SUBJECT: Engineering Review Comment  
Mountain View Electric Association Inc. (The Association)

**Project Name: Retreat at TimberRidge Filing No. 2 – Final Plat**

**Project Number: SF2121**

RETREAT AT TIMBERRIDGE
FILING NO. 2
JOB NO. 1185.20
JANUARY 4, 2021
SHEET 1 OF 7

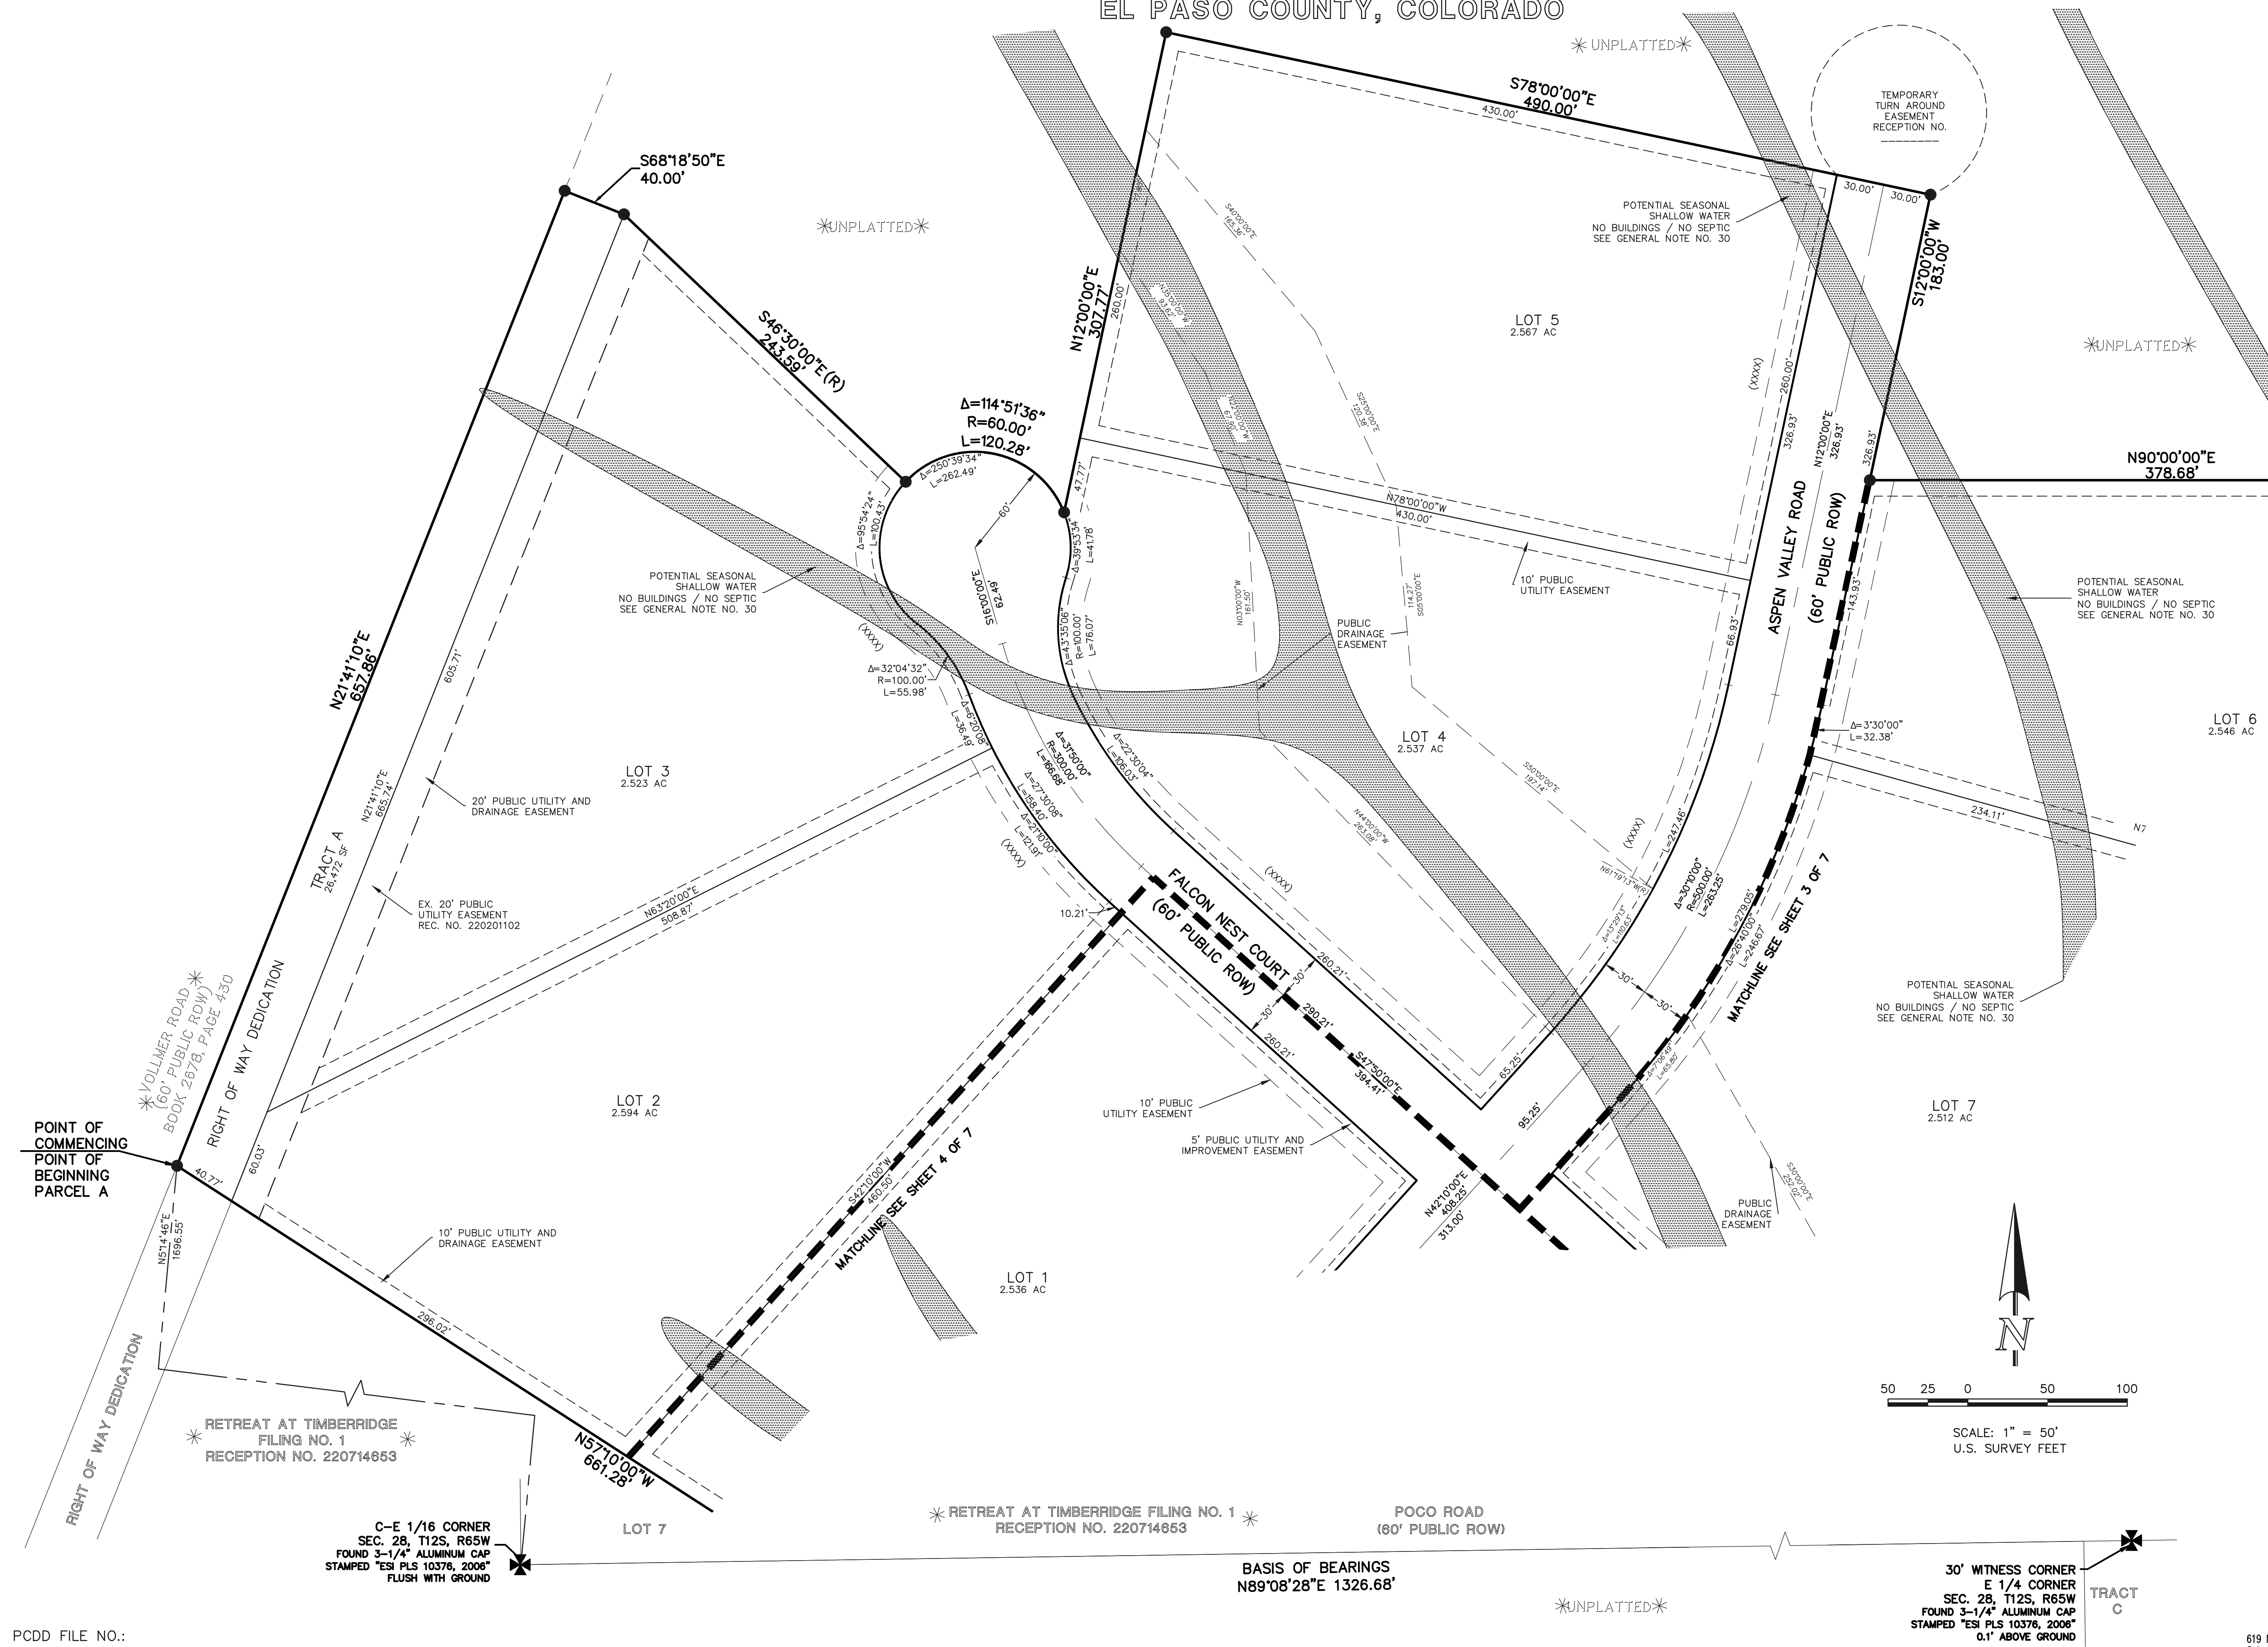
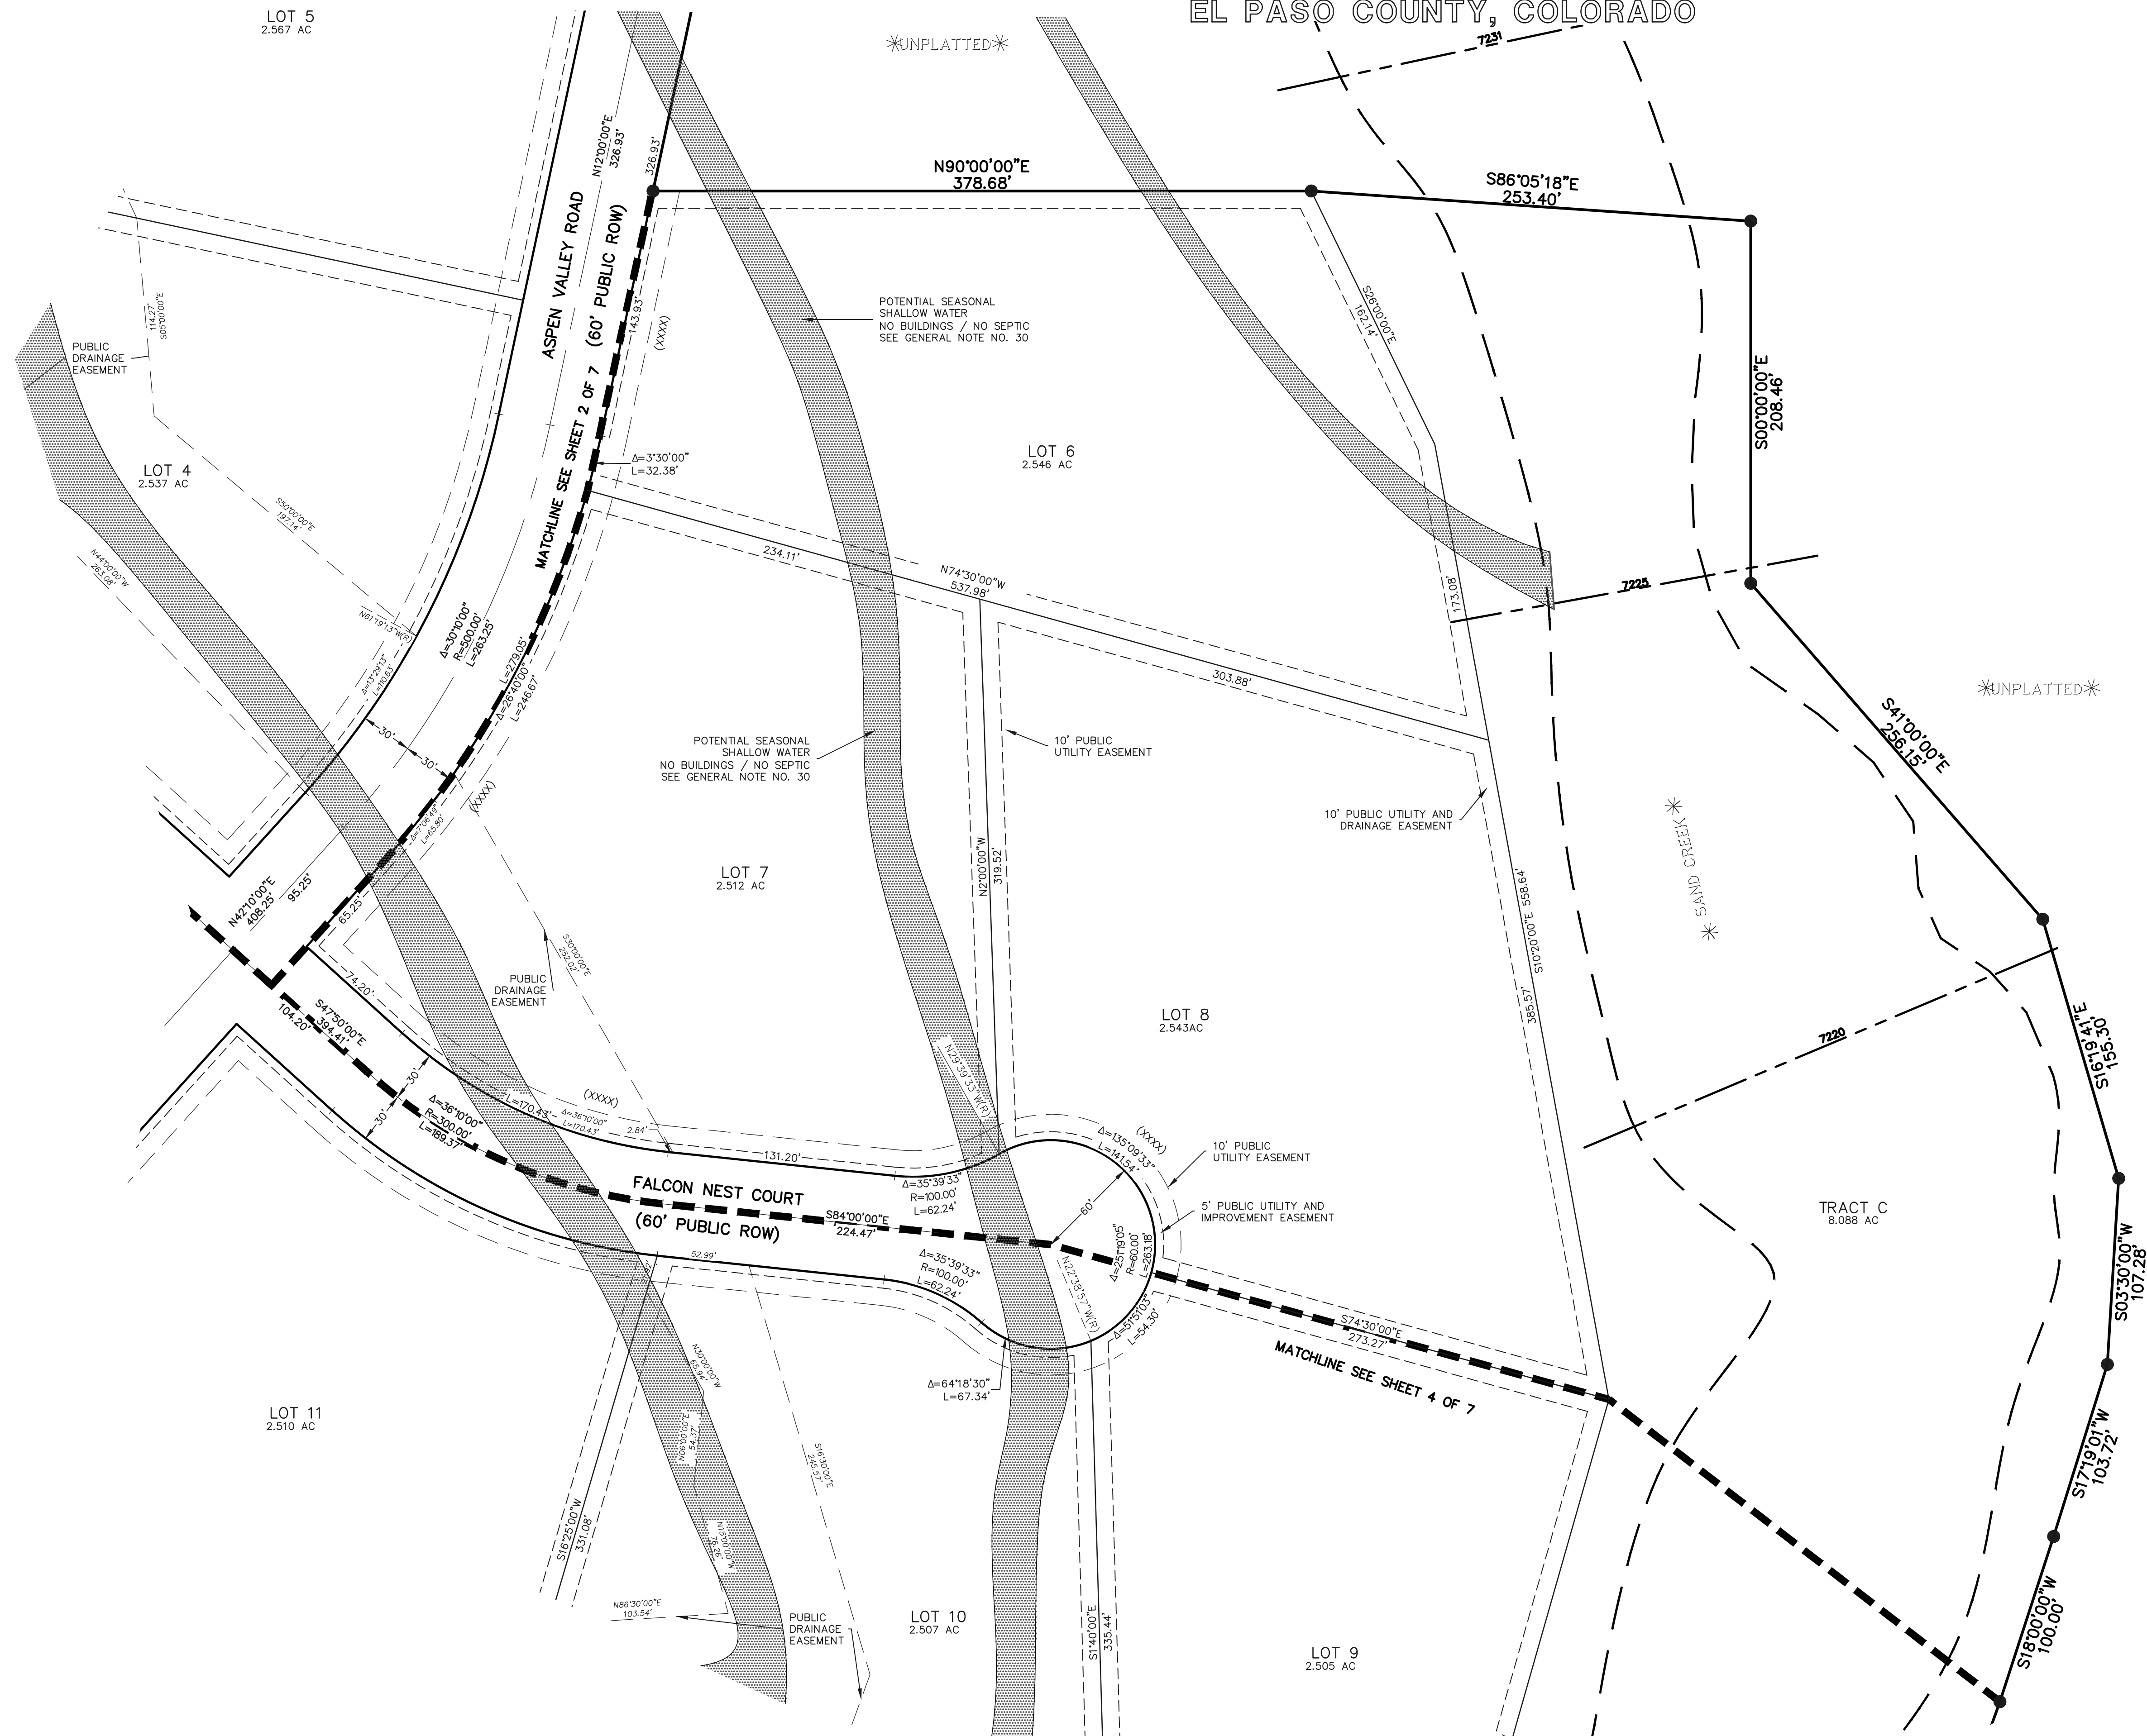
The Association requests a ten (10) foot front lot utility easement, a five (5) foot side lot utility easement, and a seven (7) foot rear lot utility easement along with a twenty (20) foot exterior utility easement on the plat and all tracts include easements. The Association also requests the platting of the Association's existing facilities with easements on the plat. Additional easements may be required.
